## **NEW HIGH SCHOOL IN BUNGENDORE**

**Application Number** SSD-14394209

I object to the proposal, for the following reason(s):

17 Additional Community Parking

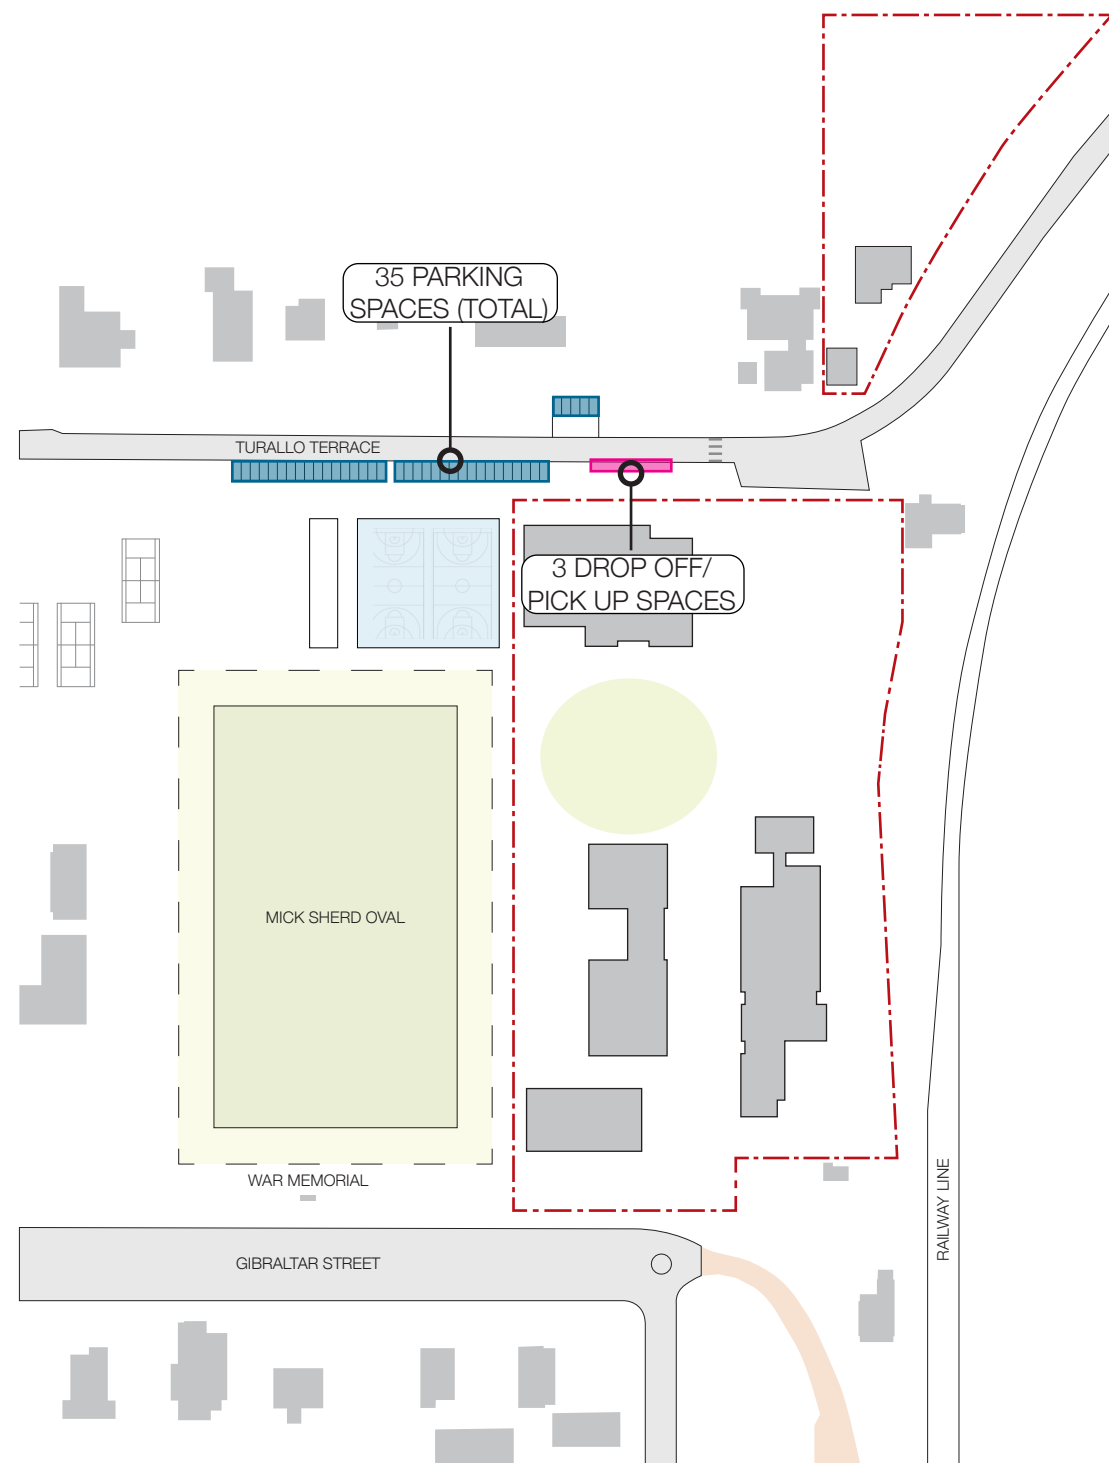
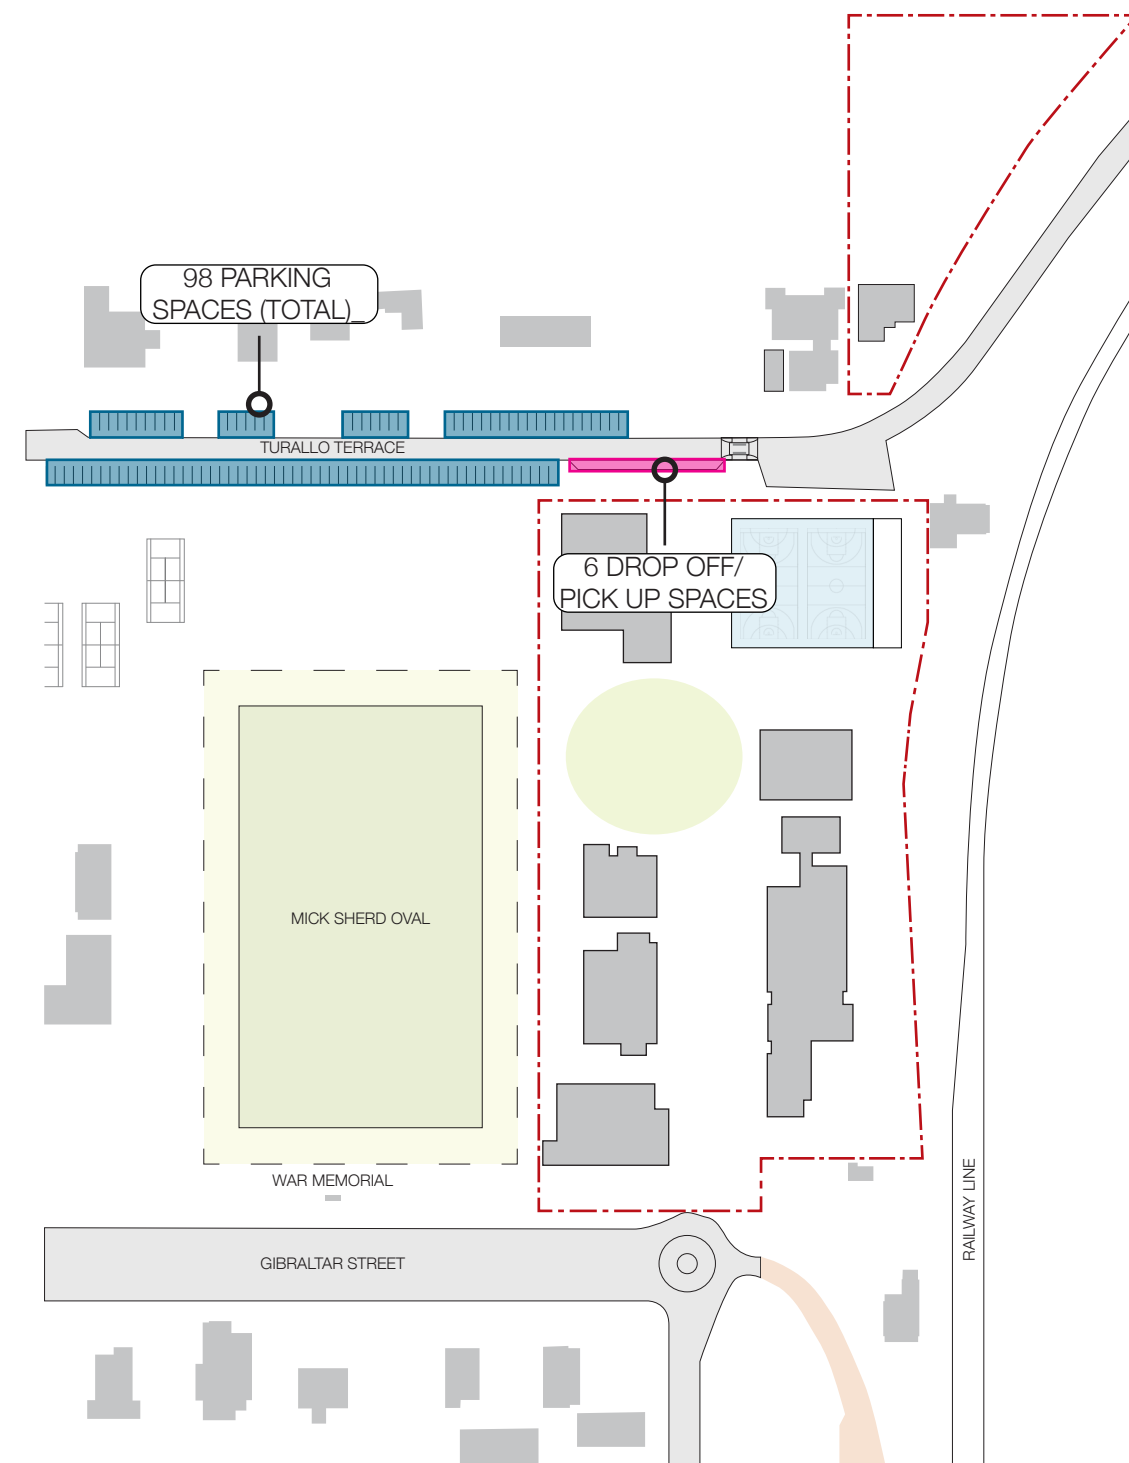
The Amendment Report states that an additional 58 car parking spaces will be provided along Turallo Terrace providing a total of 98 car parking spaces.

The report makes no reference to any consultation with residents, businesses or the church located on Turallo Terrace. DoE staff assured attendees at the information session last week that full consultation with these groups had been completed. Turallo Terrace residents have confirmed that no such consultation has ever occurred.

There is no traffic or parking safety analysis in the Amendment Report to support the creation of these additional parking spaces or to demonstrate consideration of vastly increased and chaotic traffic movements. The absence of a properly conducted analysis indicates that there has been no consideration of the following:

- impacts on traffic flow as vehicles reverse out into the traffic from both sides of the road from the proposed 90 degree parking places
- impacts on pedestrians and cyclists from the additional traffic congestion and vehicle movements associated with parking and reversing vehicles.

- impacts on student and general pedestrian safety as they move from between parked cars to cross Turallo Terrace
- Impacts on pedestrians, small children on bikes, parents with prams, etc that use the pathway between Turallo Terrace/Bungendore Park/Tennis courts and Playground and the Common and Ponds to the north of Turallo Terrace
